**Rezoning Transportation Analysis**  
**Petition Number: Insert Zoning Petition #2021-025**  
*General Location Identifier: Tax ID 16511318*

**Revision Log:**

Date	Description
02-25-21	First Review (LJ)

RZ-1.0

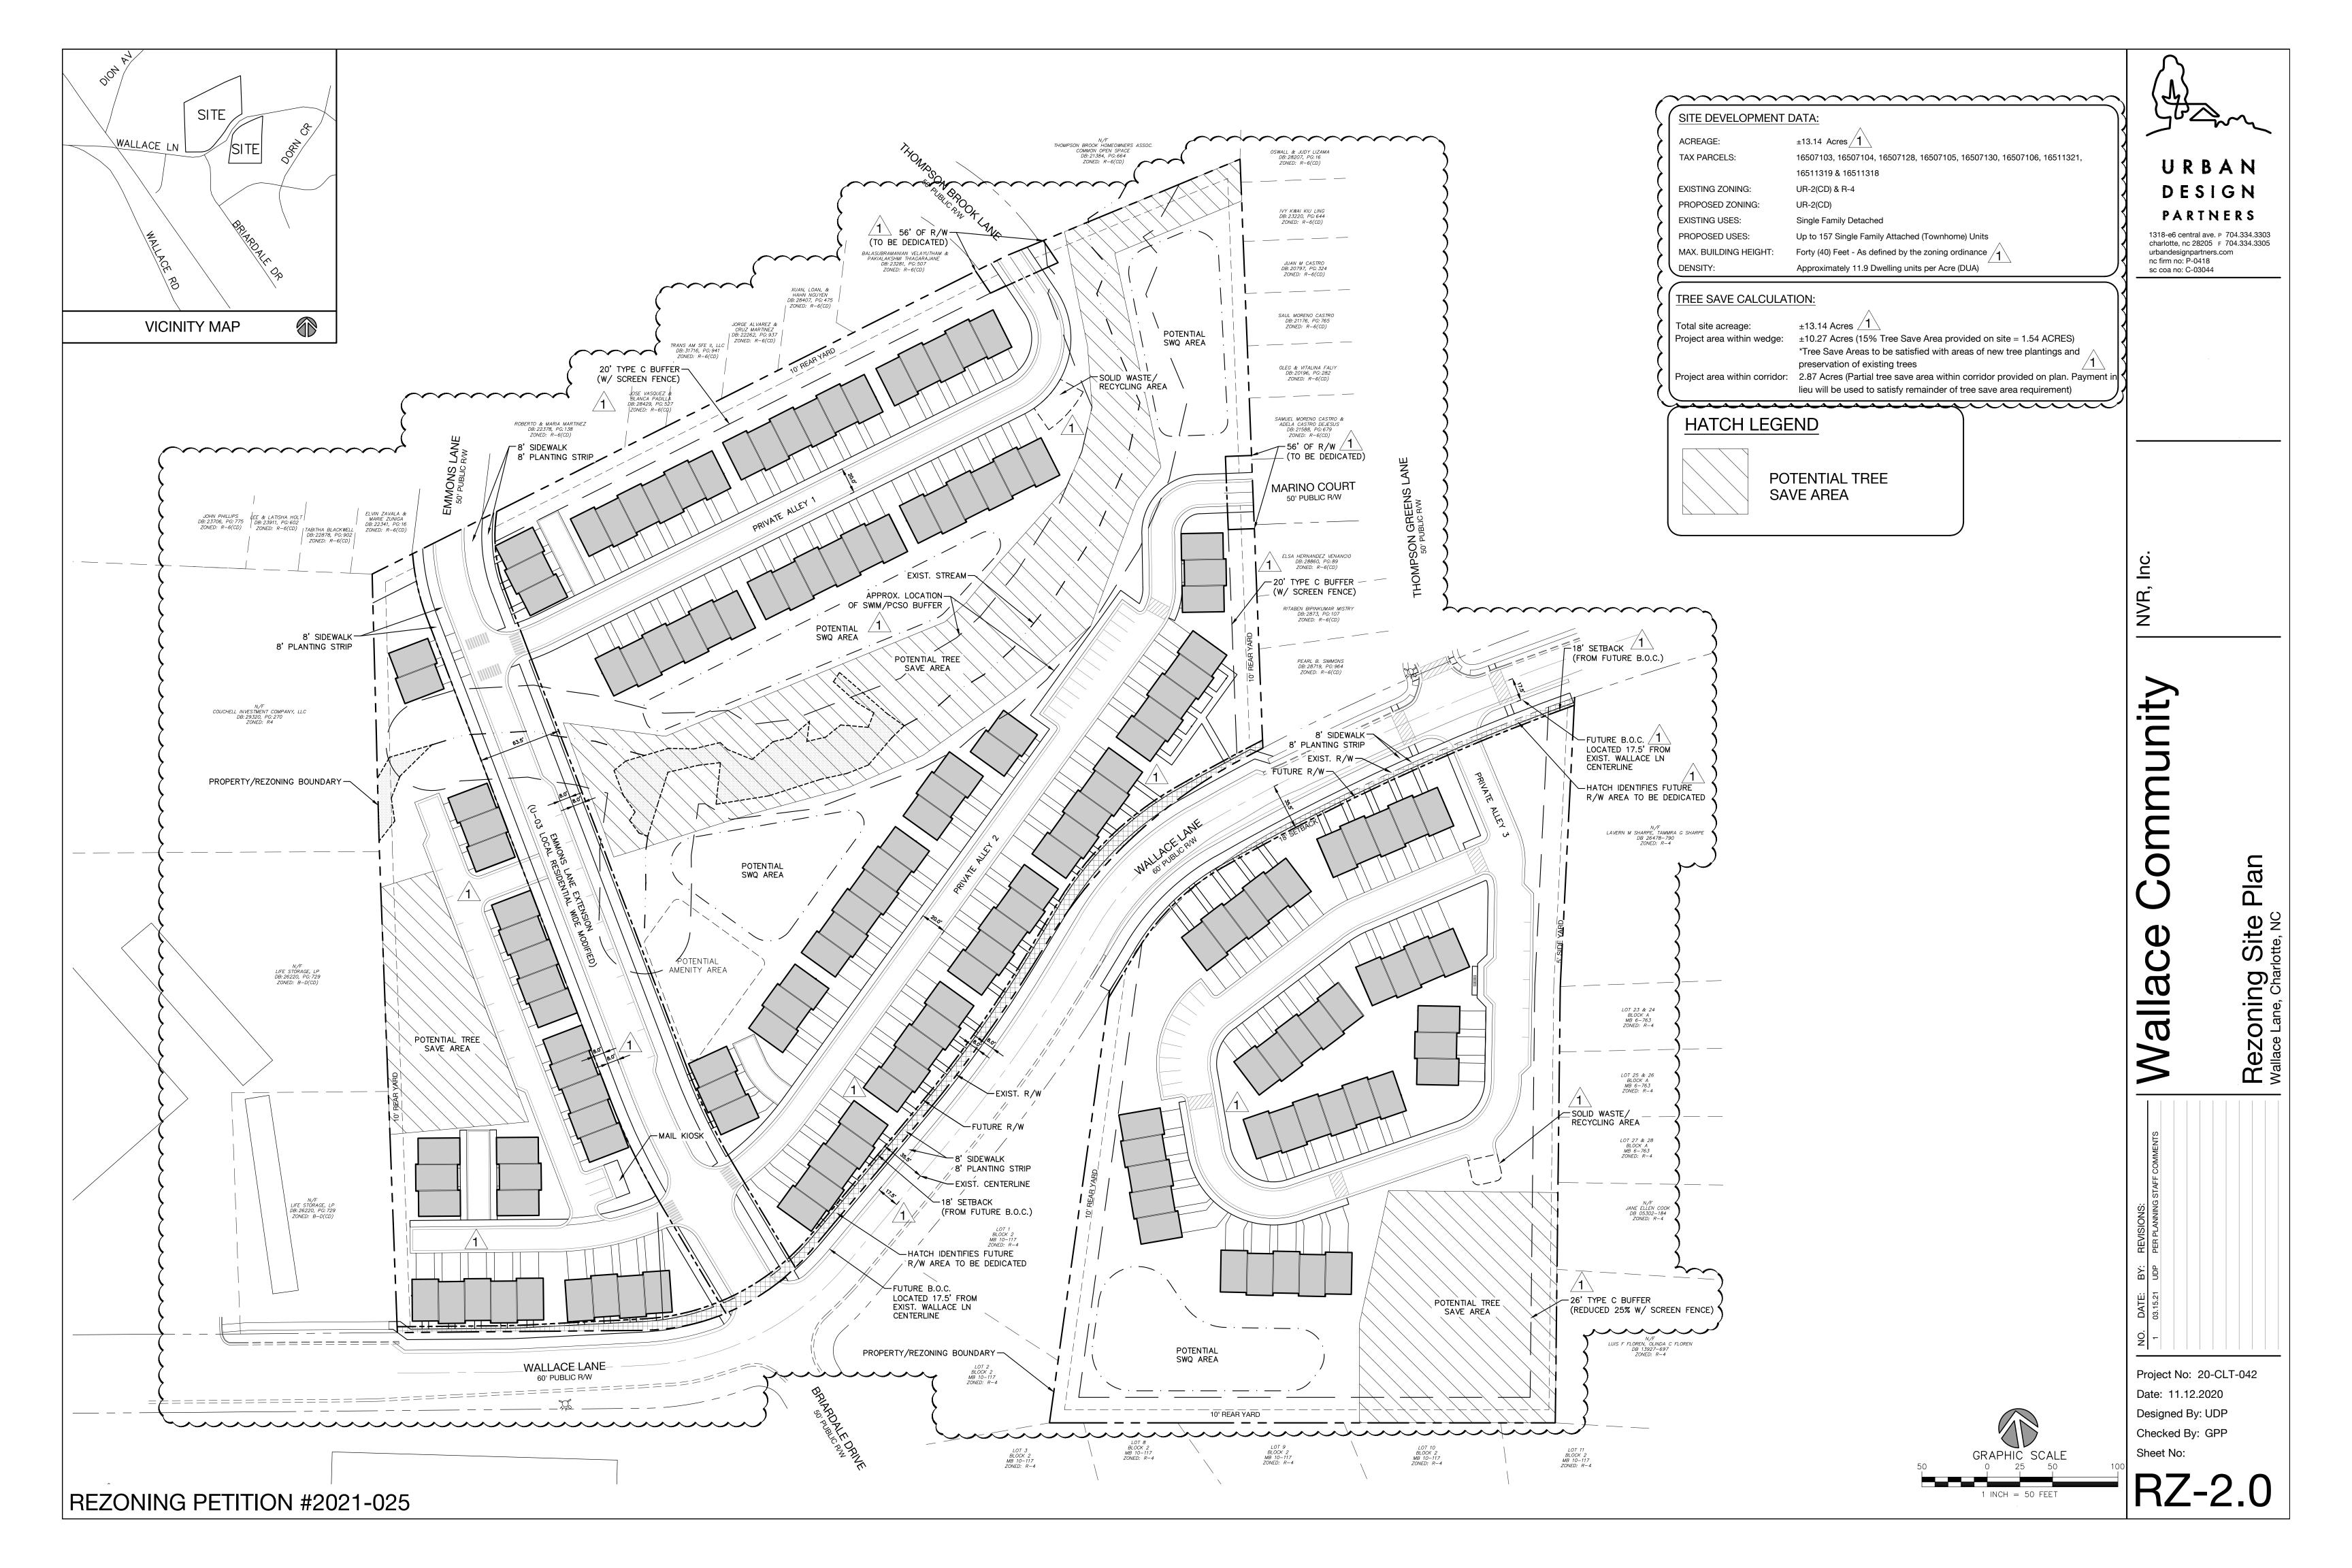
1. **Curblines:** The proposed zoning district has a setback measured from back of the existing or proposed future curblines.
  - a. **Wallace Lane:** The future location of back of curb and gutter is 17.5' from the Wallace Lane centerline. The curb and gutter needs to be labeled and dimensioned from the road centerline to the back of curb on the site plan.

3. Revise site plan and conditional note(s) to commit to dedicate 35.5' right-of-way from the road centerline. The site plan shall label and dimension the right-of-way from the road centerline.

4. Revise site plan and conditional note(s) to commit to construct an 8-foot planting strip, and 8-foot sidewalk on Wallace Lane and Emmon Lane extension per Chapter 19 / Chapter 20. The site plan shall label and dimension both items from the back of curb and gutter and road centerline. CDOT requests rights-of-way set at 2' behind back of sidewalk where feasible.

5. Revise site plan to provide for Private Alley 1 and Private Alley 2 to be private streets, as opposed to alleys, to allow for better connection to the existing public road street stubs.

6. Revise site plan and conditional note(s) to provide alley access for Emmon Lane townhome driveways or obtain driveway distance standard for townhomes on Emmon Lane public road as required in City of Charlotte Driveway Regulations.
